**Swati Sharma - Fwd: Exhibition of Environmental Assessment for Googong Water CycleProject (Major Project 08/0236)**

Thankyou for the invitation to comment on the Environmental Assessment (EA) for the Googong Water Cycle Project. Environment Protection, Department of the Environment, Climate Change, Energy and Water has reviewed the EA. In general it appears to be a robust and thorough assessment of the potential environmental impacts of the proposal.

Figure 11.2 Vegetation communities, flora and fauna

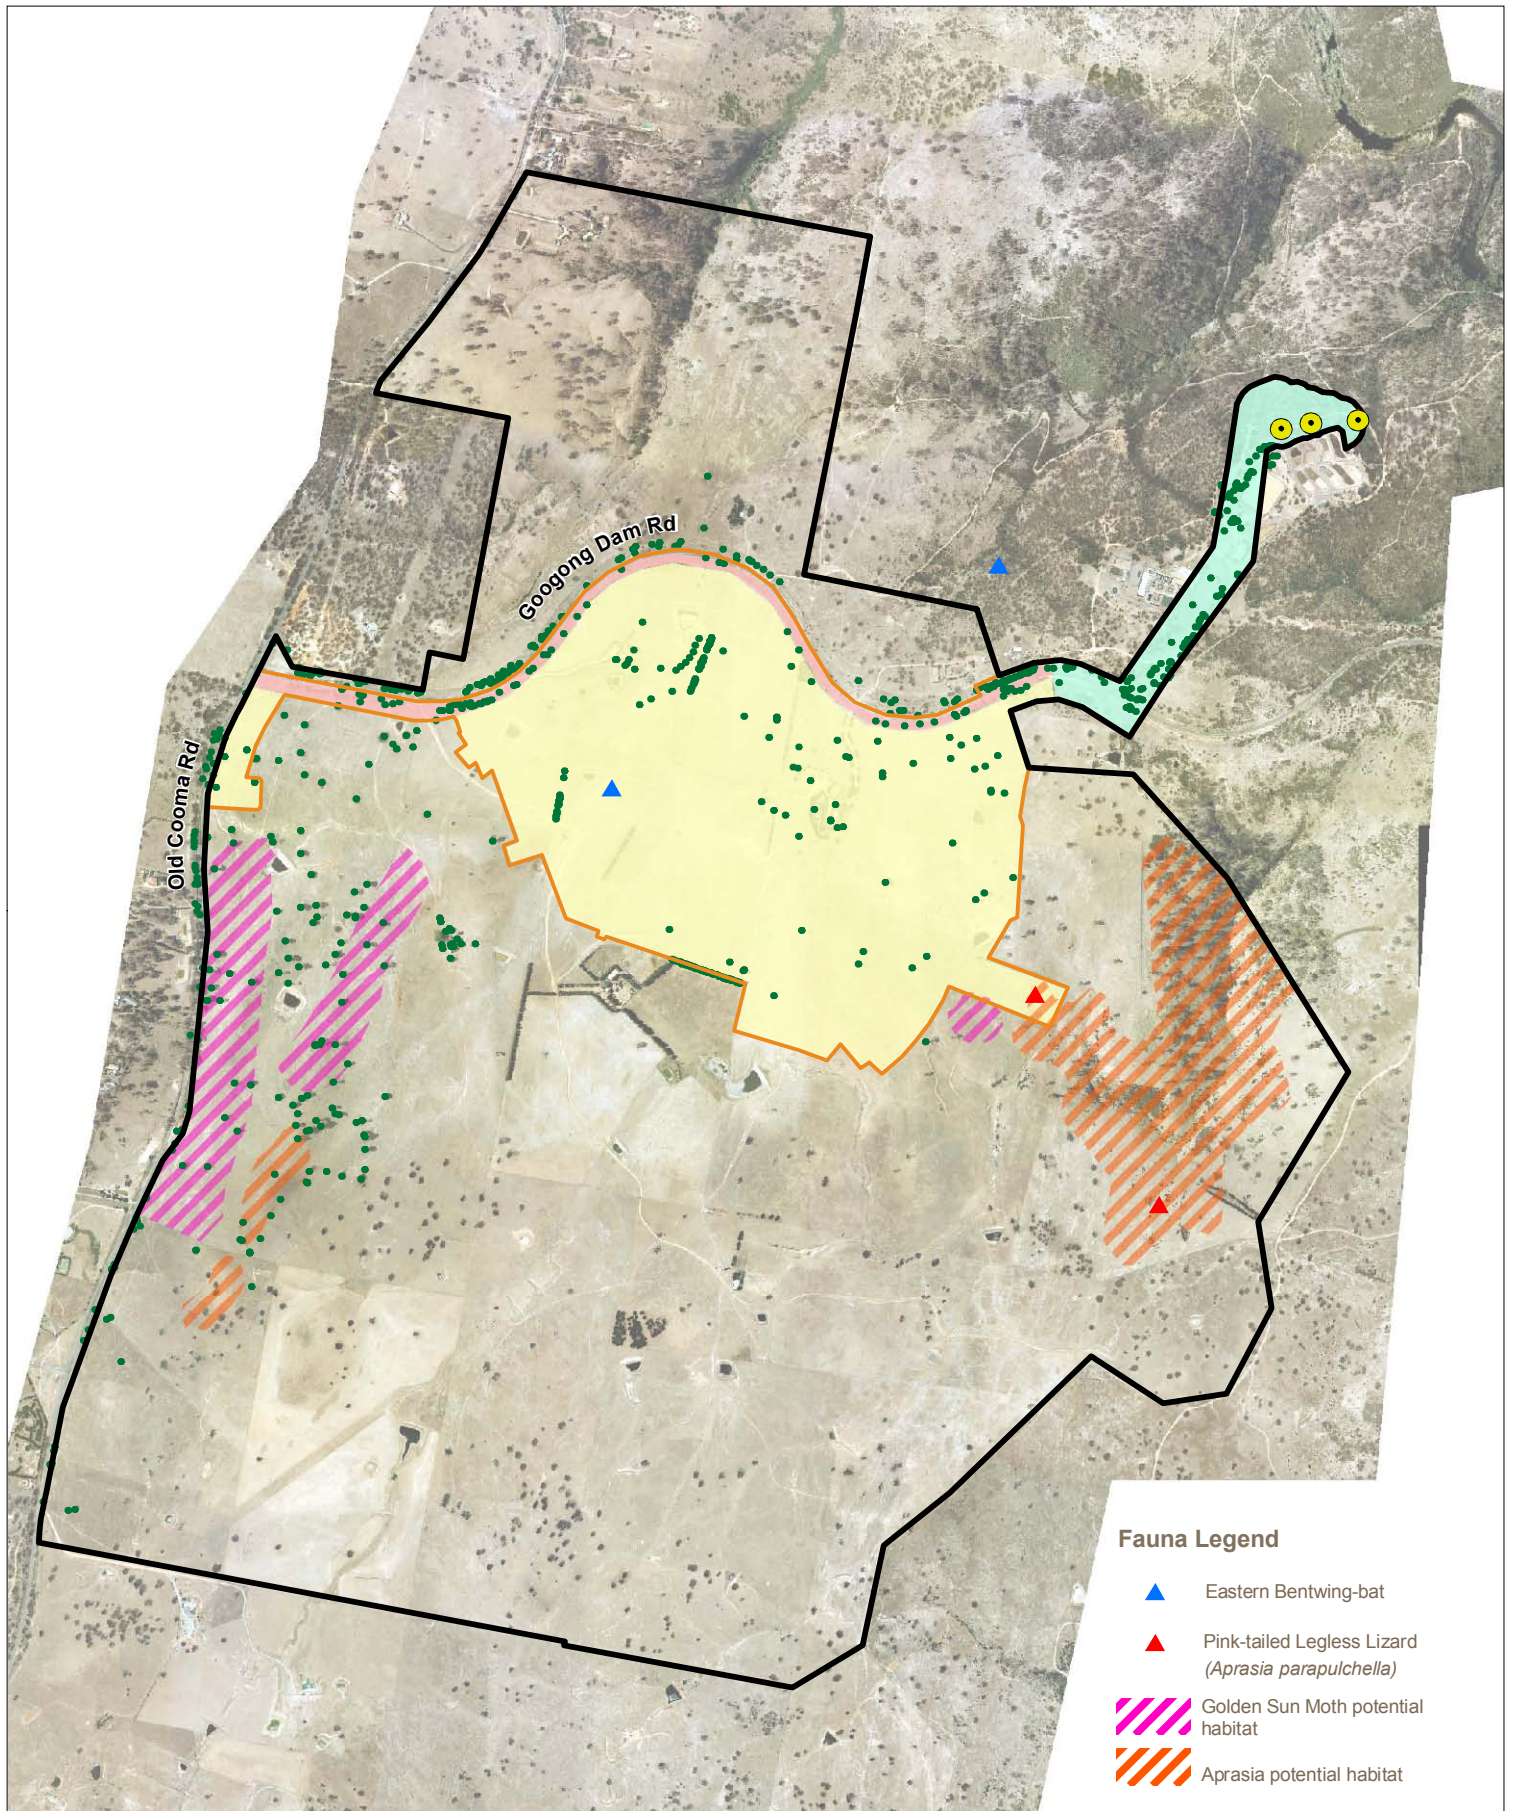
The EA states that the development will consider and avoid potential impacts on Pink-tailed Legless Lizard and Hoary Sunray habitat (page XV of Executive Summary). The Pink-tailed Legless Lizard is a declared species in the ACT, and the regional impacts on ACT populations should be considered. Any clearance of habitat should be avoided, and offset if damage can't be avoided. The development should include consideration of cumulative impacts on the species.
